Engineers Comments Regarding Surface Water Drainage

Application Reference:	P/76/26/PL	Reviewer Reference:	ADC/EXT4b
Planning Officer:	Amber Willard	Date of Review:	15/09/2026
Site Name:	Sefter Farm Pagham Road Pagham PO21 3PX		
Application Description:	Construction of a new engineering block building and car parking areas together with a new access road, footpaths and hard standing area. This application may affect the setting of a listed building and is in CIL Zone 5 (Zero Rated) as other development.		
Assessment Number:	1

DETAIL 'D' PERMEABLE ASPHALT CONCRETE  
FOOTPATH CONSTRUCTION DETAIL  
(Scale 1:20)

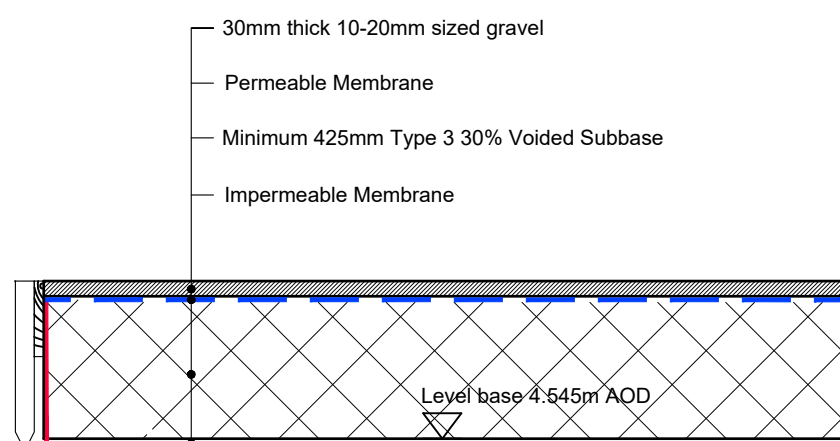
- 3.2. Calculations are provided which indicate the design storm can be contained within the permeable pavement voided subbase stone layer without flooding. However, the subbase of the footpaths has been calculated with a porosity of 1. This needs to be corrected as the model currently assumes open storage within the subbase of the footpaths, when in fact it is a 30% voided subbase.

TITLE Proposed Site Layout And Positively Drained Areas Plan	
SCALE 1:500 @ A3	PROJECT No. 24125
REPORT TYPE FRA	DRG. No. 03

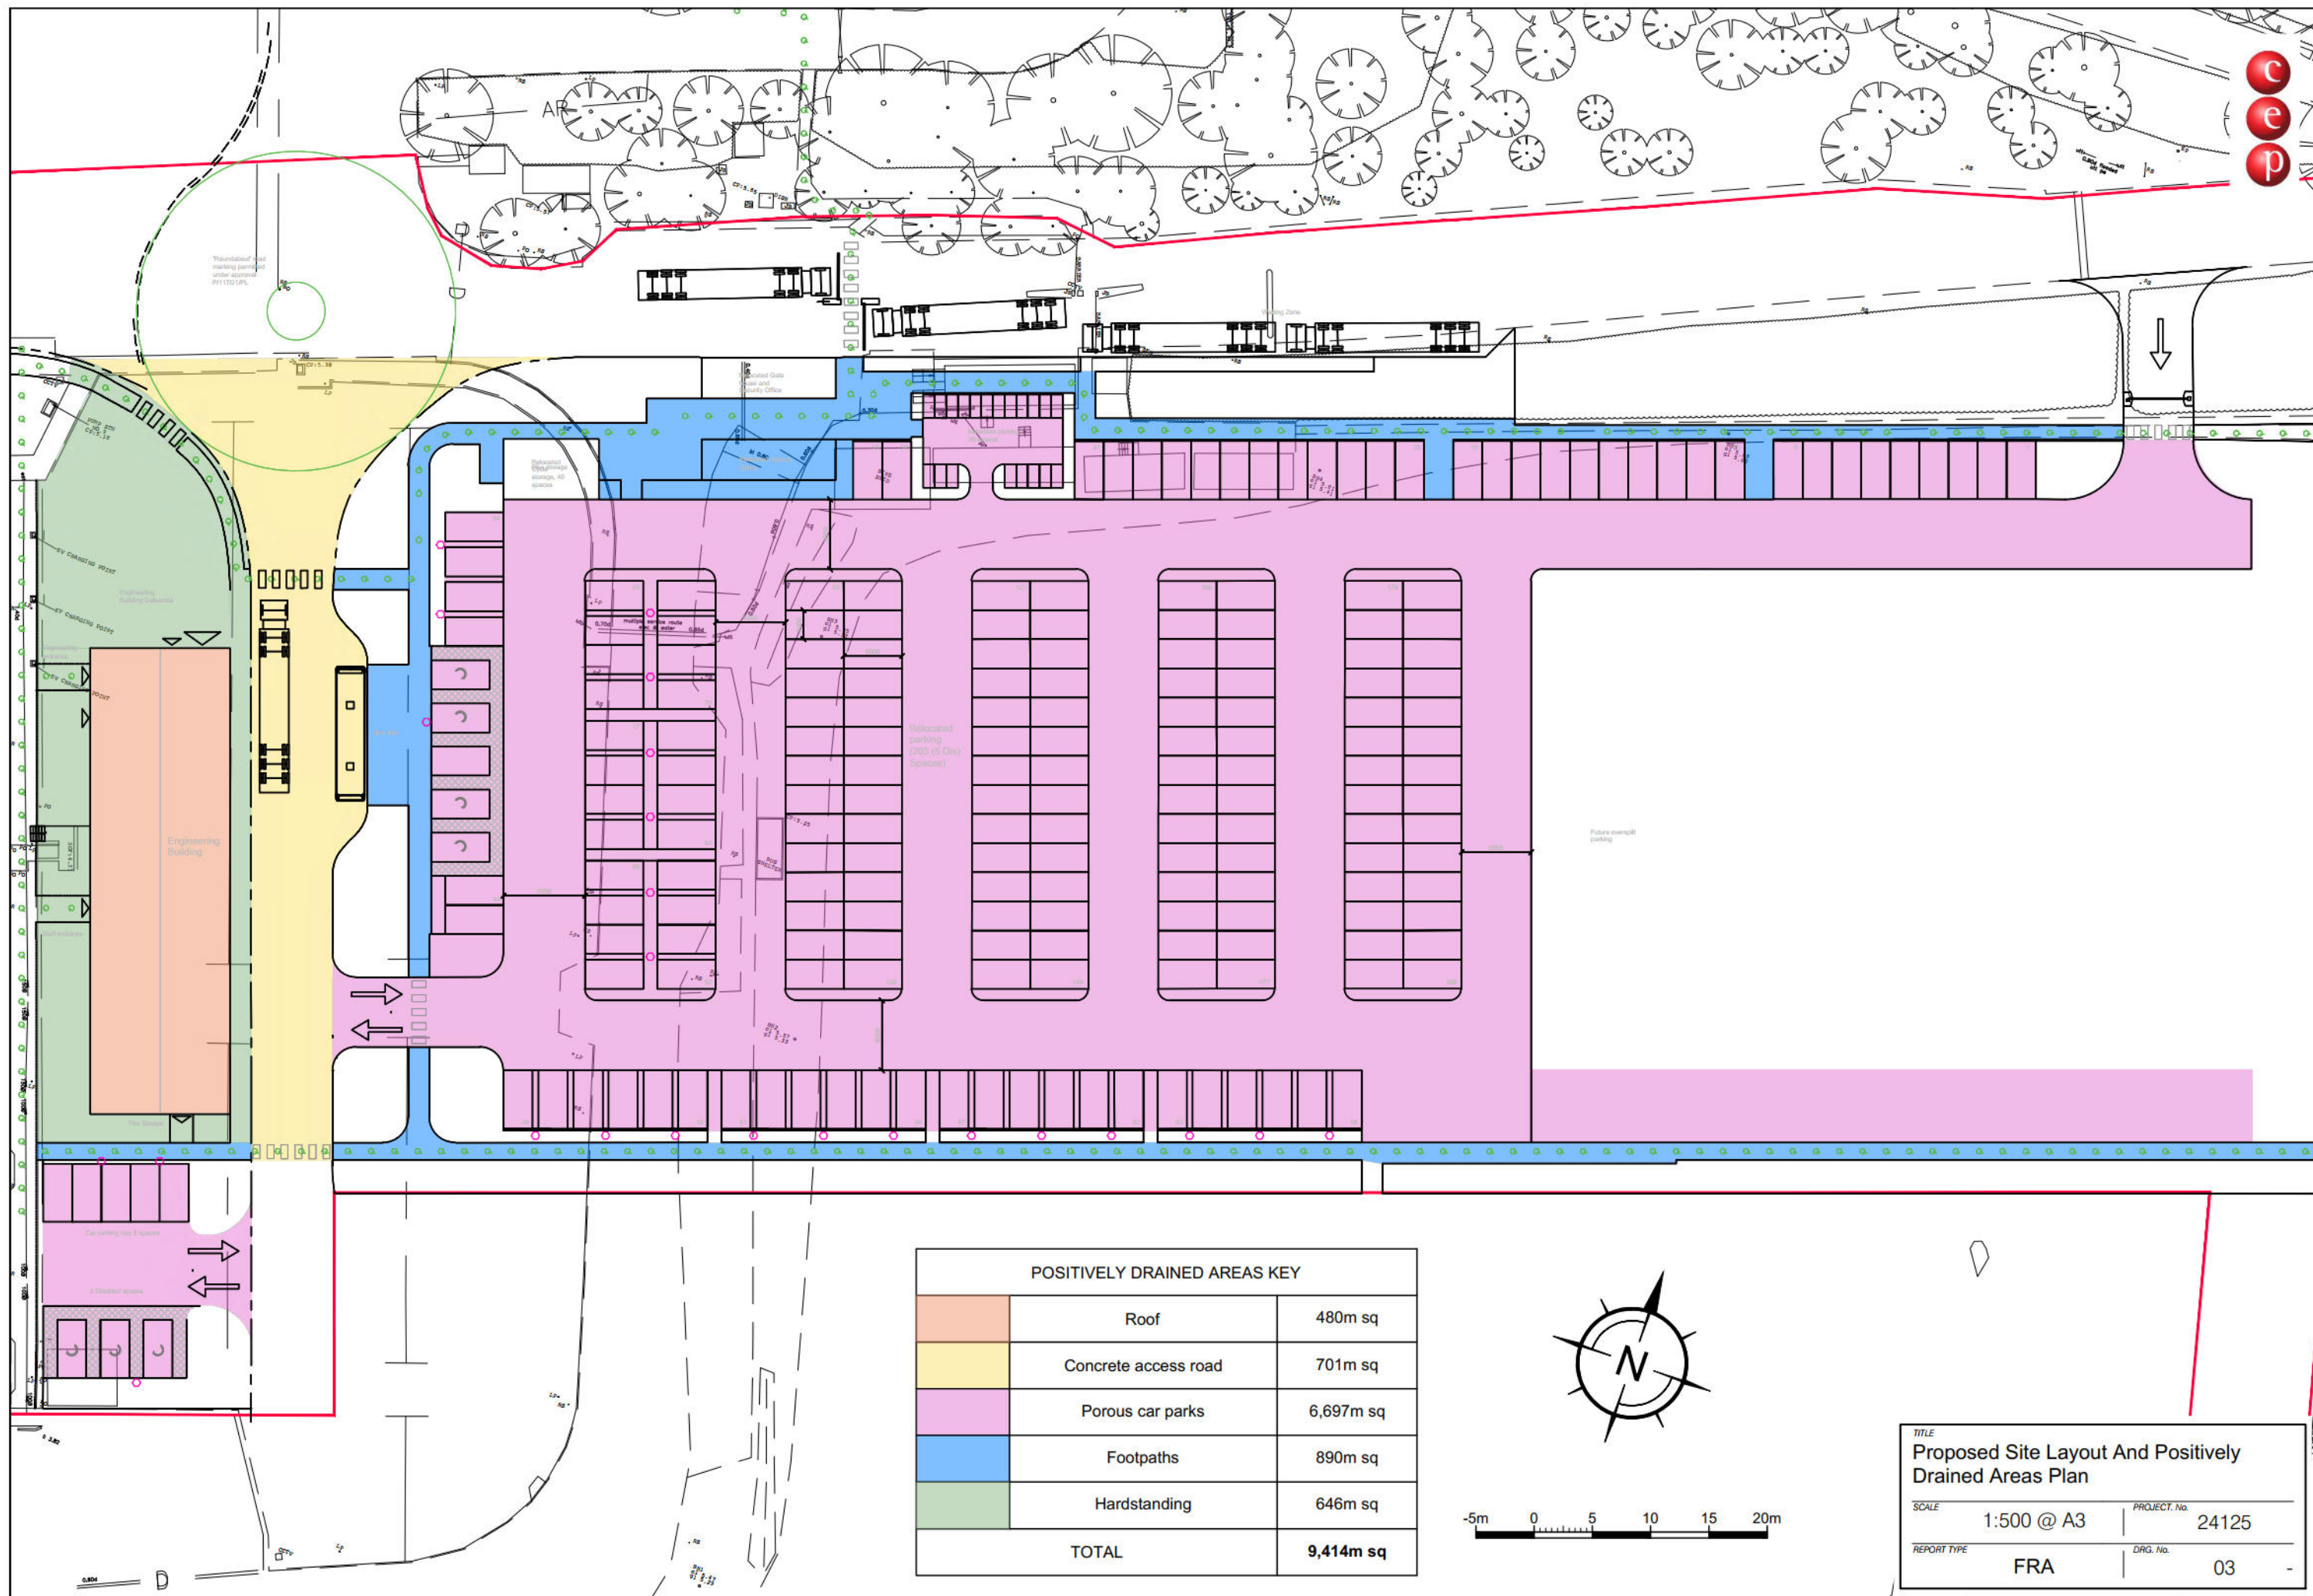
- 3.5. However, there is an area of subbase storage to the east of the car park which should be clarified whether the area will remove topsoil and should be included in the drained area. There is also a smaller area linking the existing and new access road which should be included in the calculations.
